DEVELOPMENT REVIEW BOARD
SUPPLEMENTAL SUBMITTAL

July 26, 2019

Re: Tract 11-A & 11-B Avalon Subdivision, Unit 5 (Project # 2019-002402)

Enclosed are the responses to the comments provided during our April 24th hearing. Comments and responses are listed below by department.

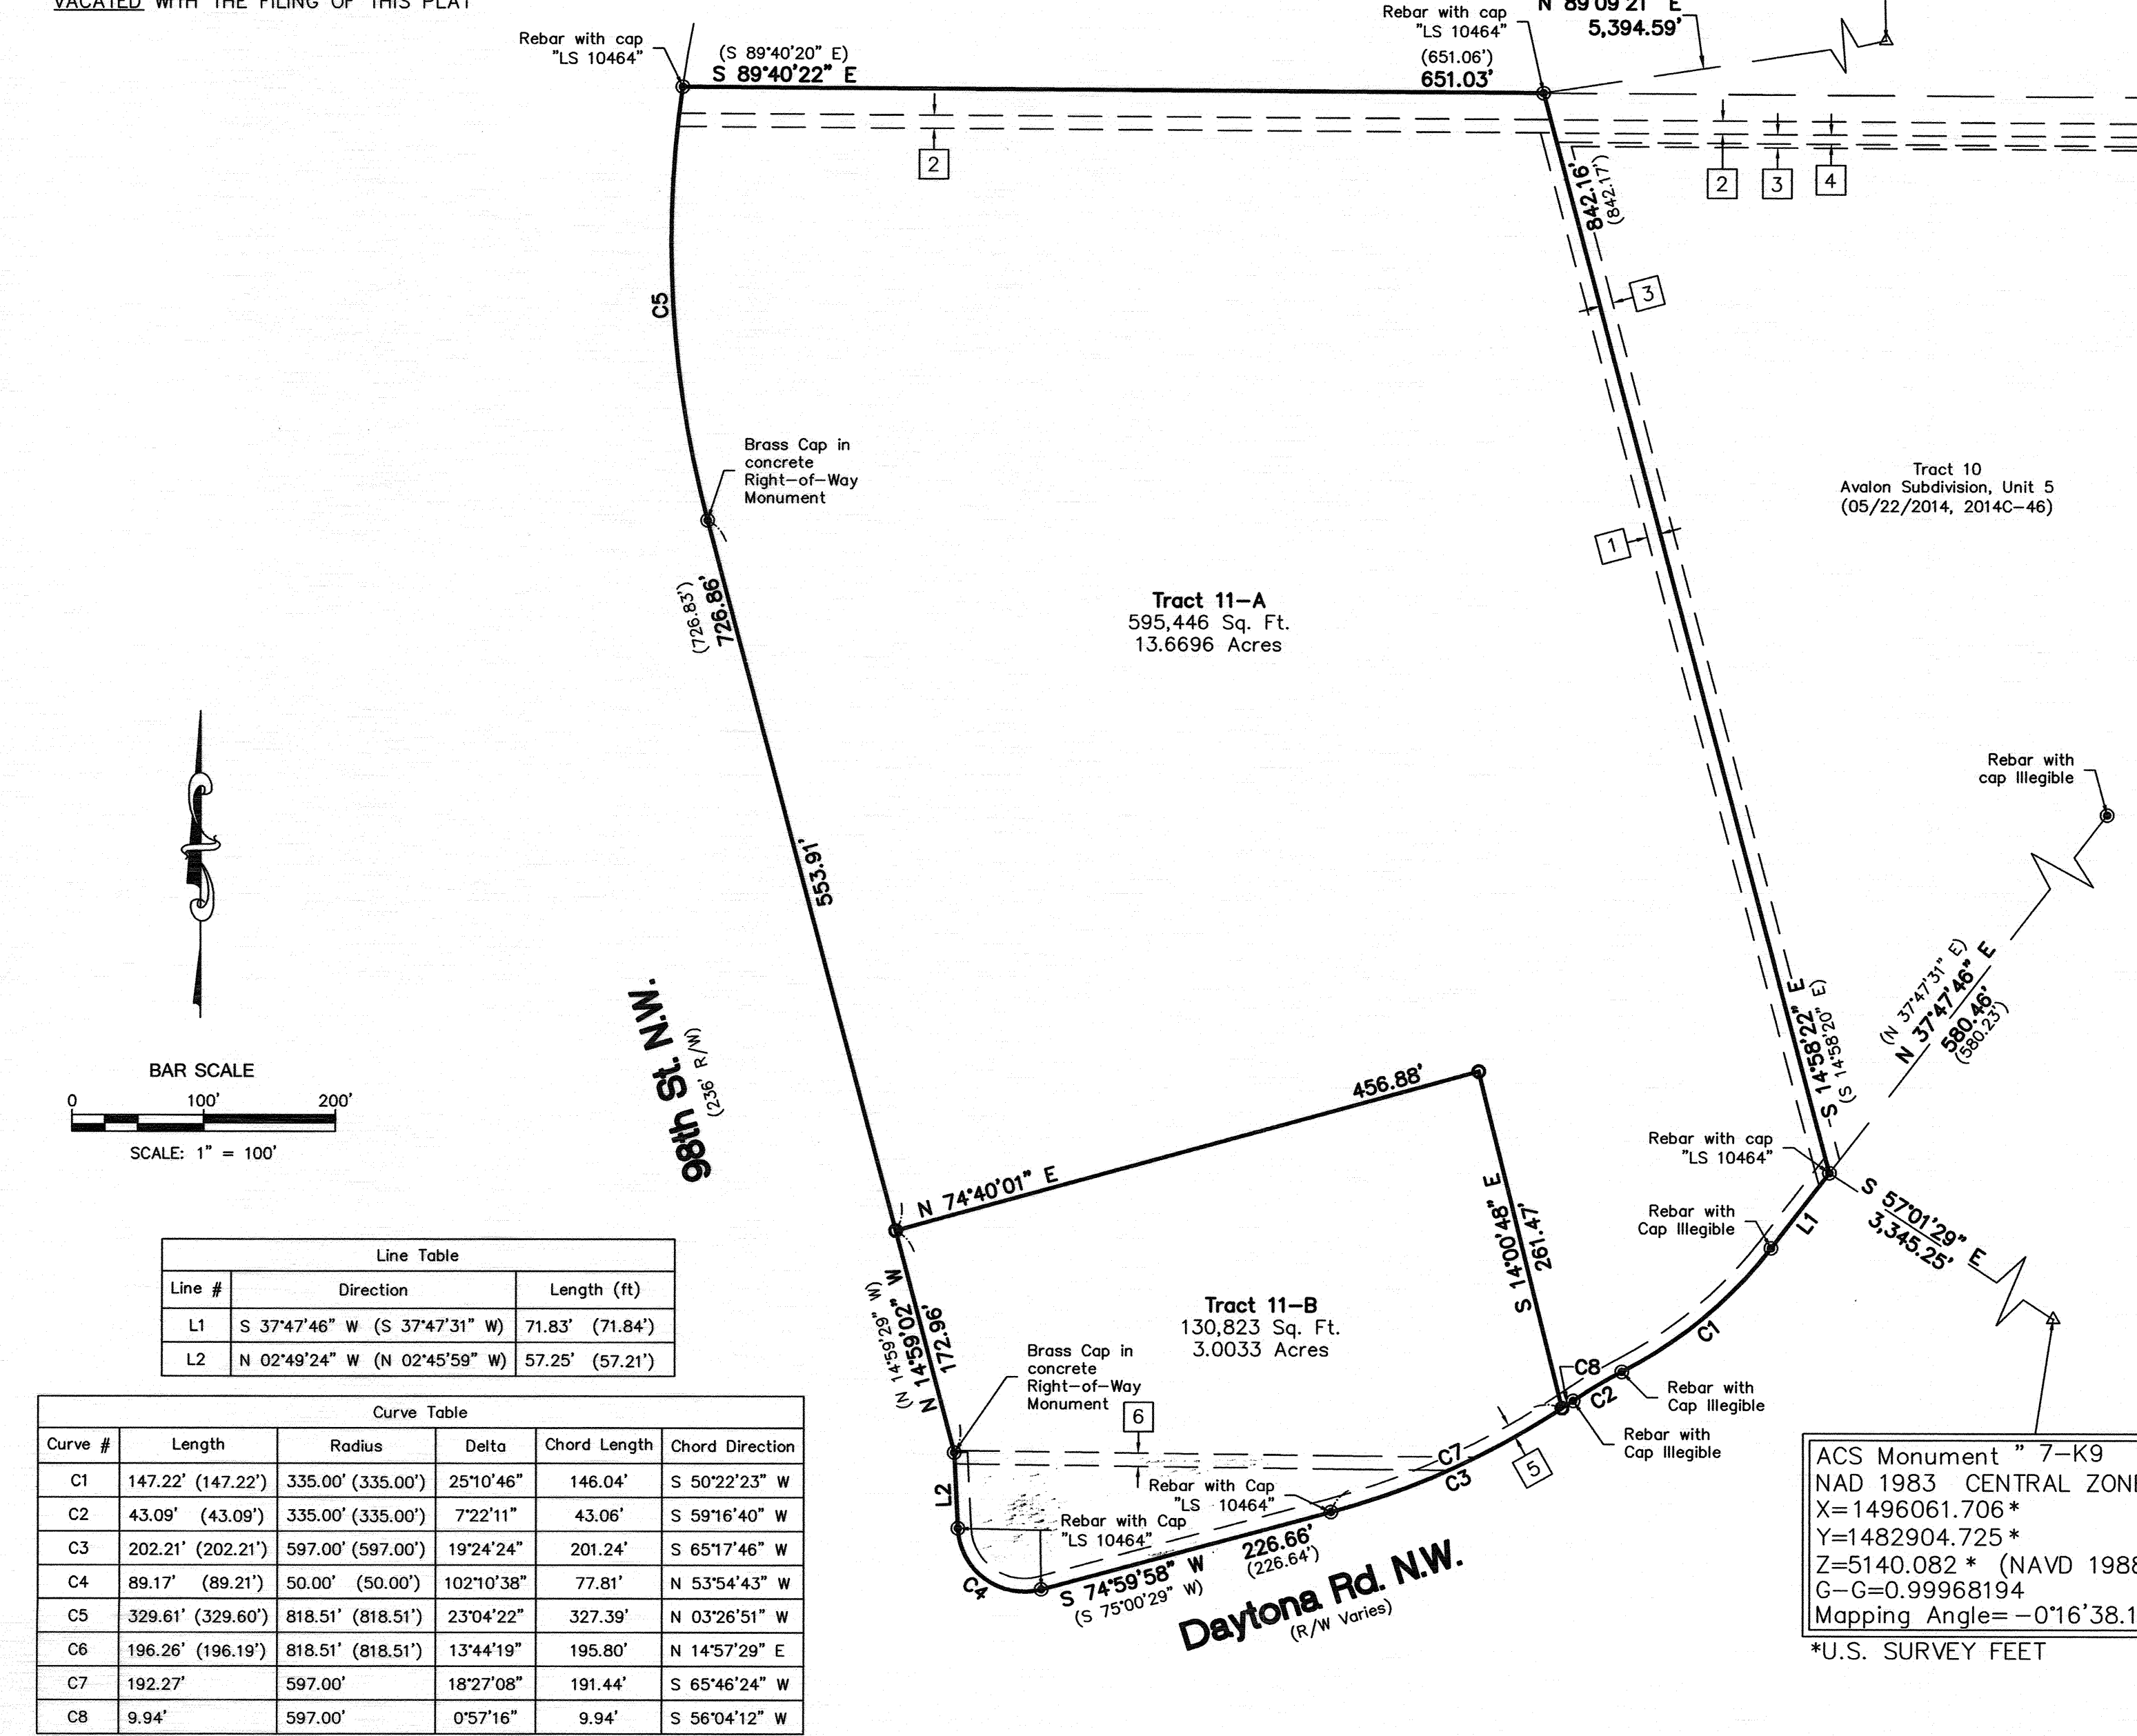
1. Sheet 2 of the plat mislabels Bluewater Road and Daytona Road. Please correct this.
Response: The plat now correct labels Bluewater Road
2. For final plat, any access easements need to be shown with all beneficiaries and maintenance responsibilities listed.
Response: Noted
3. Infrastructure is required to bring the transportation facilities in this area up to current standards. Provide an infrastructure list for approval.
Response: Infrastructure List has been provided and contains all required transportation infrastructure.
4. The Traffic Impact Study (TIS) needs to be approved prior to approval of the infrastructure list.
Response: The TIS is in the process of being reviewed. The infrastructure list reflects all required transportation infrastructure per the draft version of the TIS.

# SIDEWALK EXHIBIT

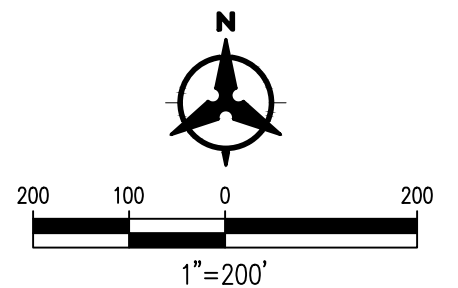
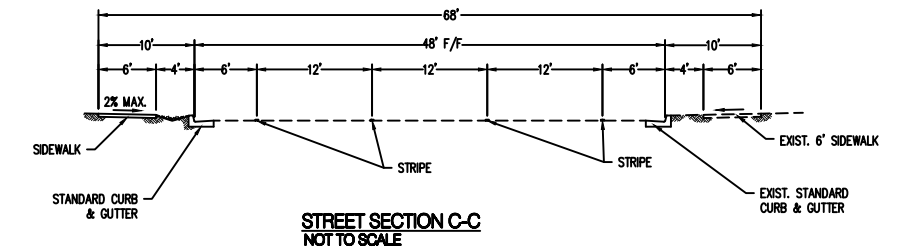
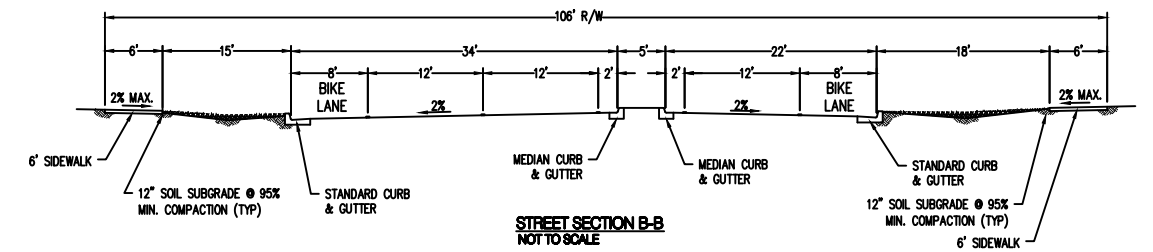
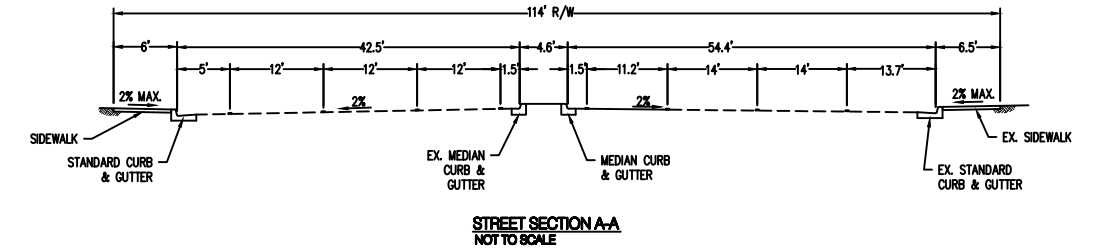
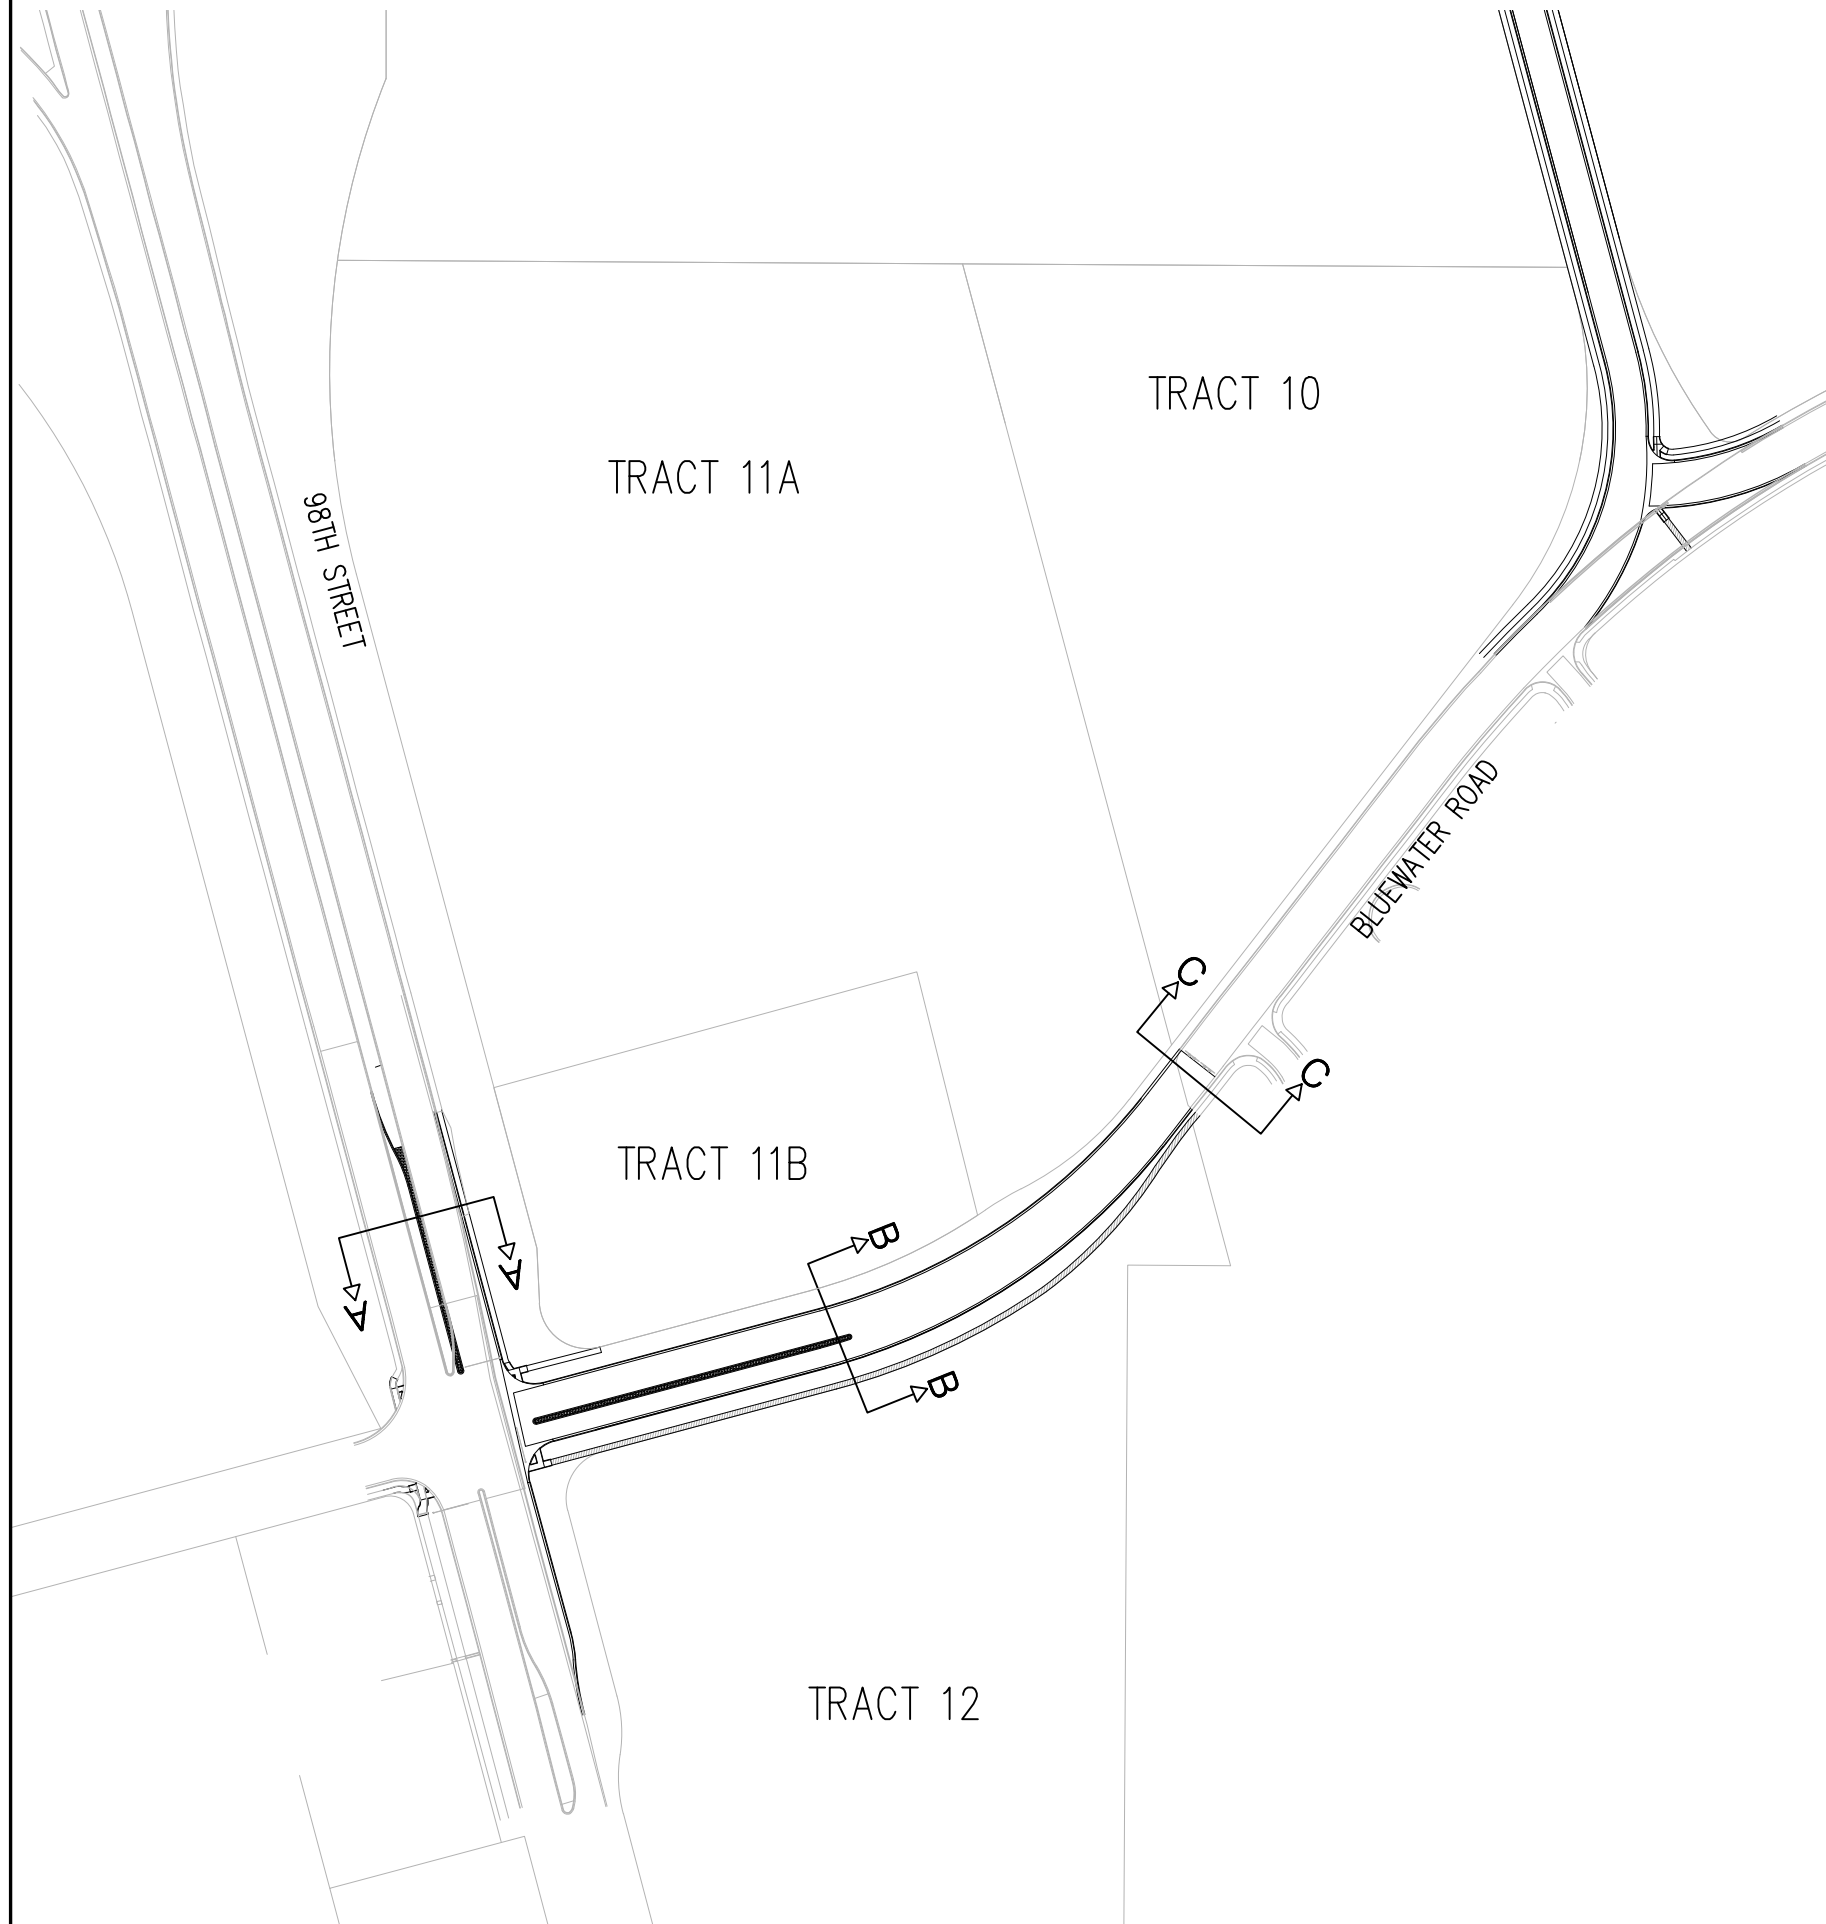
Response: Noted
2. Per the 2040 Long-range Bikeways System Map, Bike lanes are required on 98th St. and Bluewater Rd. Bike lanes should measure 6 feet wide from lip of curb and be explicitly identified on the Sidewalk Exhibit and the Infrastructure List for both of these roadways.

3. Street names shown on the Plat do not match the prior 2013 plat and the infrastructure list does not appear to be consistently referenced to roadways as shown the Plat. The Infrastructure List, Sidewalk Exhibit and Plat should to be updated to accurately reflect the location of the proposed improvements.

Response: Proposed Bluewater Road will include 6' wide bike lanes. Existing Bluewater Road does not have bike lanes currently. The only improvements to 98th Street are intersection modifications, northbound right turn lane, and southbound left turn lane. 98th Street does not currently have designated bikes lanes. Bike lanes are now more explicitly shown on the sidewalk exhibit. The infrastructure list now denotes the required 6' bike lane along Bluewater Road.

Response: Infrastructure List, Sidewalk Exhibit, and Plat have all been updated to correctly reflect street names
4. The required traffic impact study was not provided in the application materials so it was not possible for DMD to conduct a complete review of this application, therefore comments provided are limited to the information contained in the application.
